# SHOPS AT MERIDIAN RANCH CONVENIENCE STORE

## LOT 2, THE SHOPS FIL. NO. 1A AT MERIDIAN RANCH

### Grading & Erosion Control Plans

#### El Paso County, Colorado

DRAWING NO. 2
 LANDSCAPE PLAN

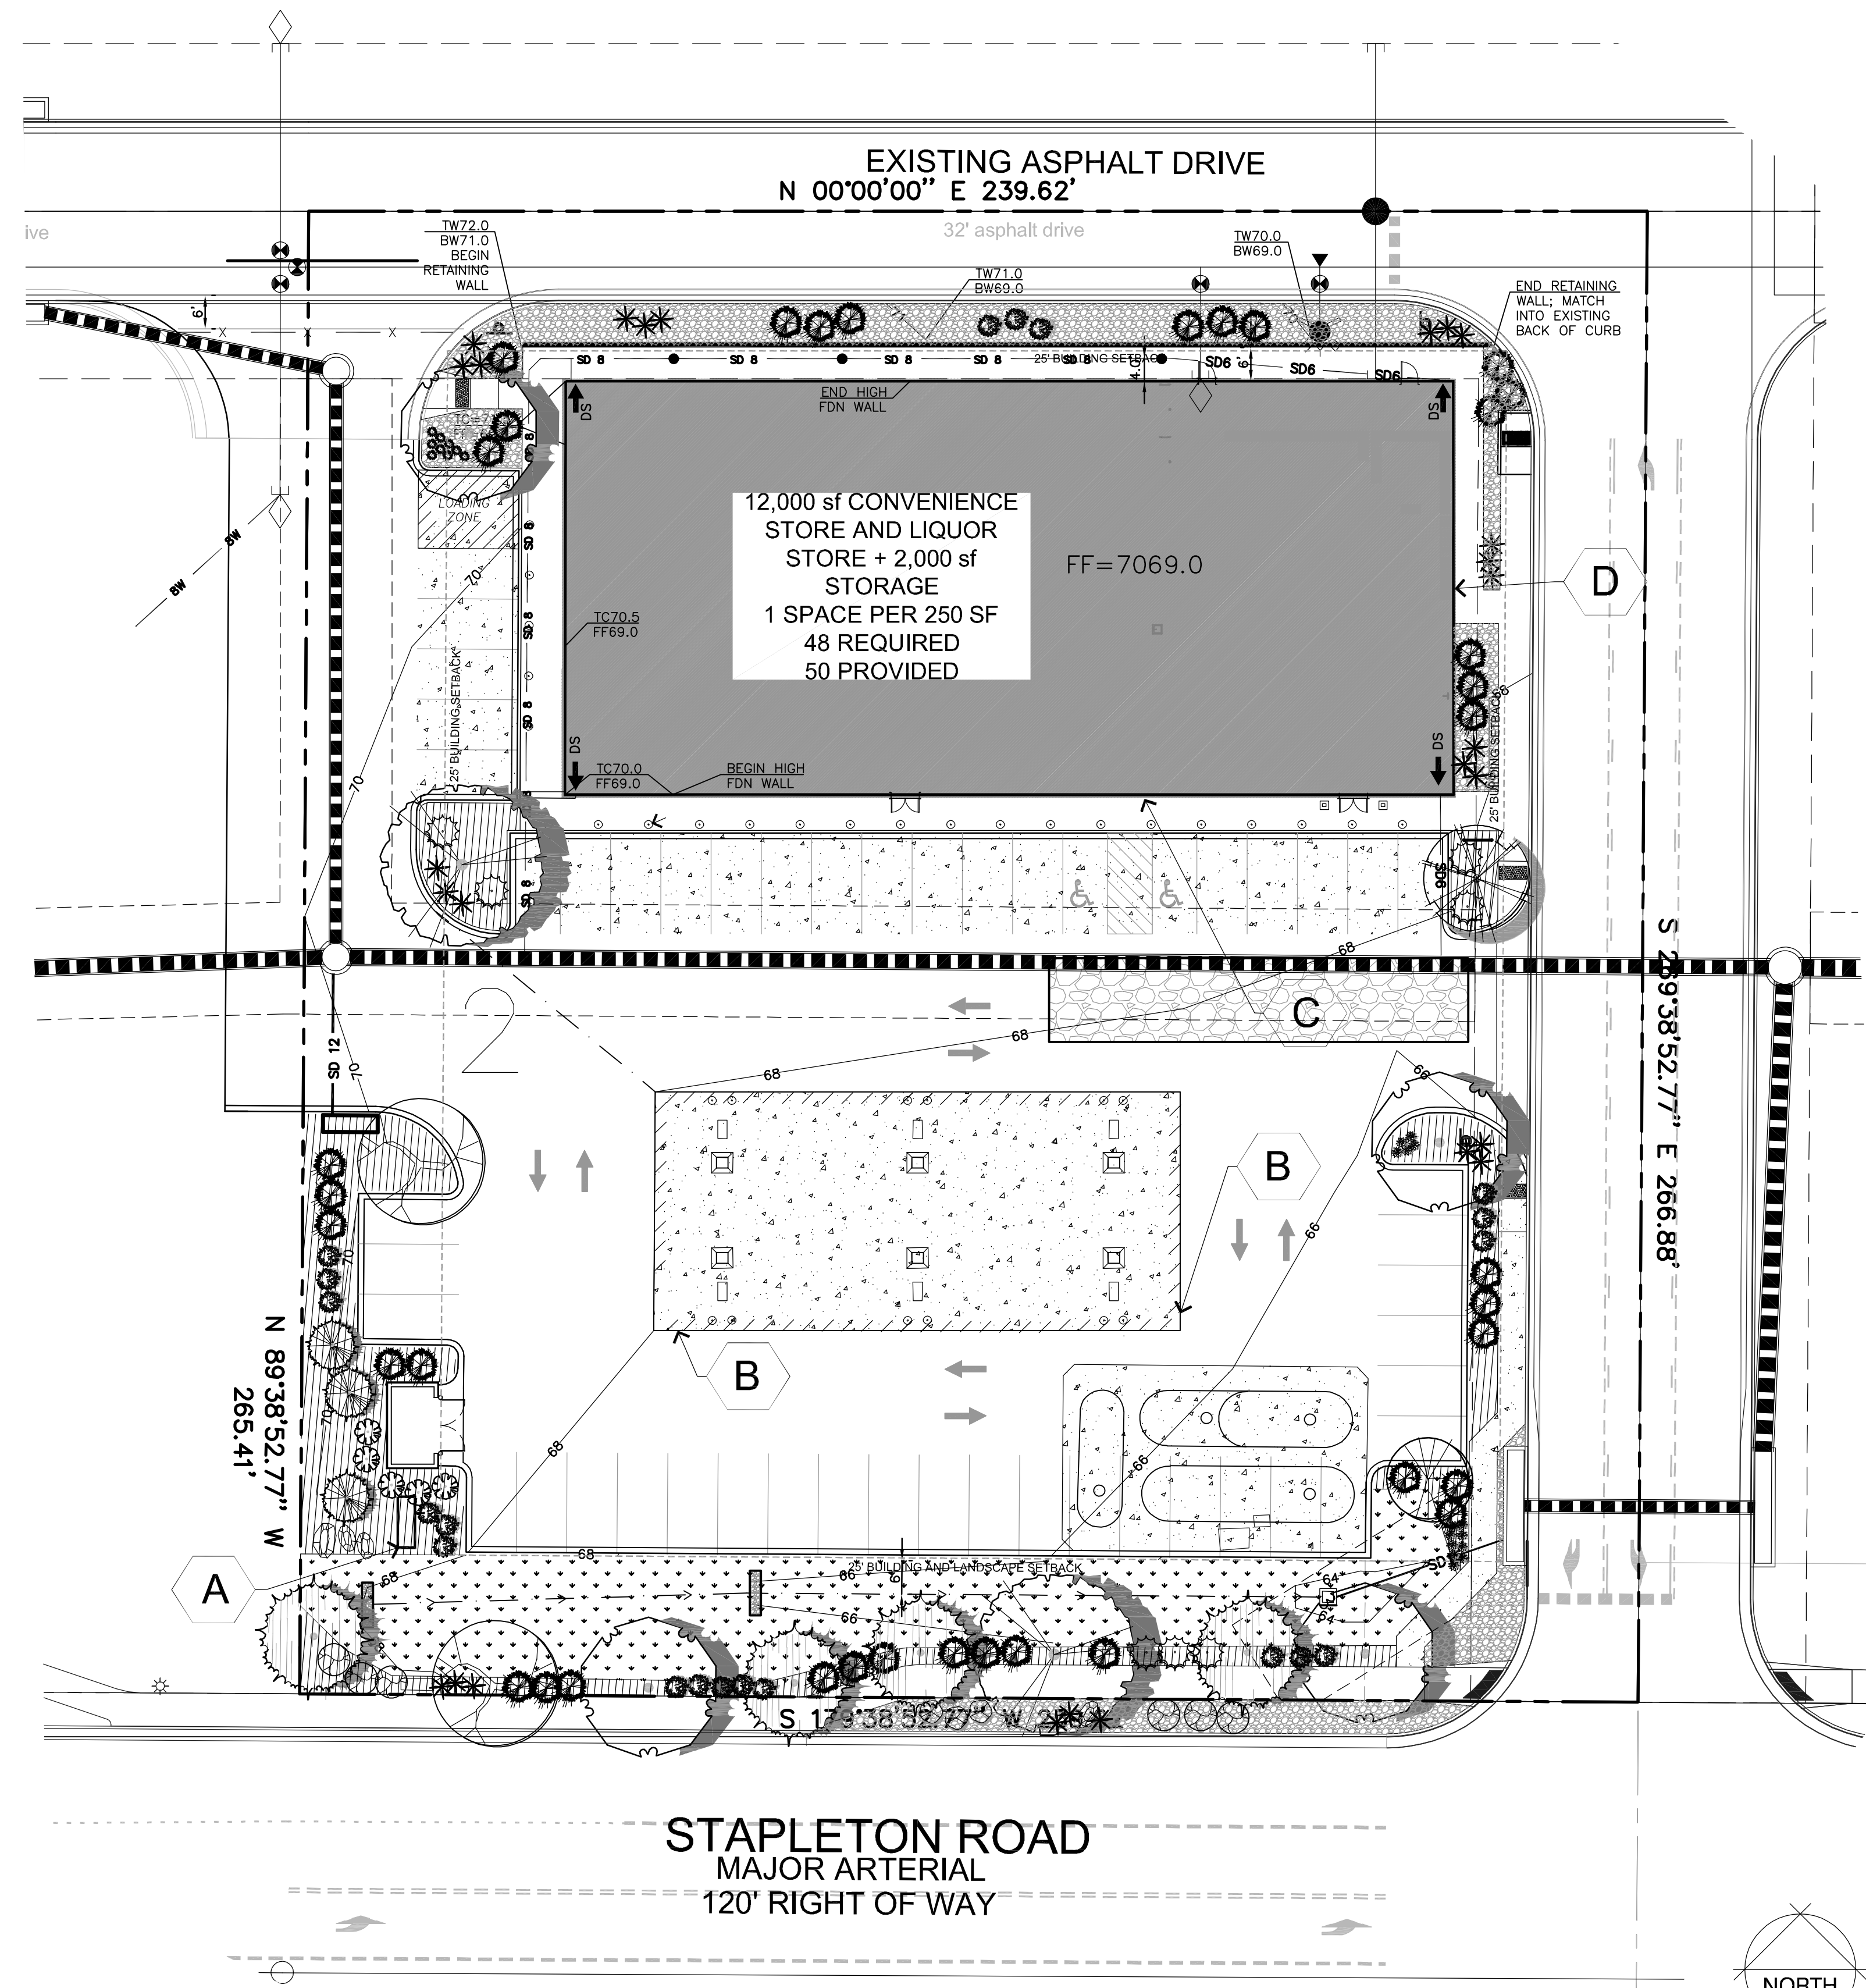
Unresolved comment from Review 1: Compare this whole area to what is shown on the Landscape Plan (LP). The LP shows that most of this area will be 2-4" cobble which contradicts the SM shown on this GEC plan. The cobble also wouldn't allow for runoff reduction, which requires turf grass. Revise to remove discrepancies between LP, FDR, and GEC Plan.

Review 2 update: Landscape Plan still shows some of this turf/seeded area as cobbles. See my comments on the Landscape Plan.
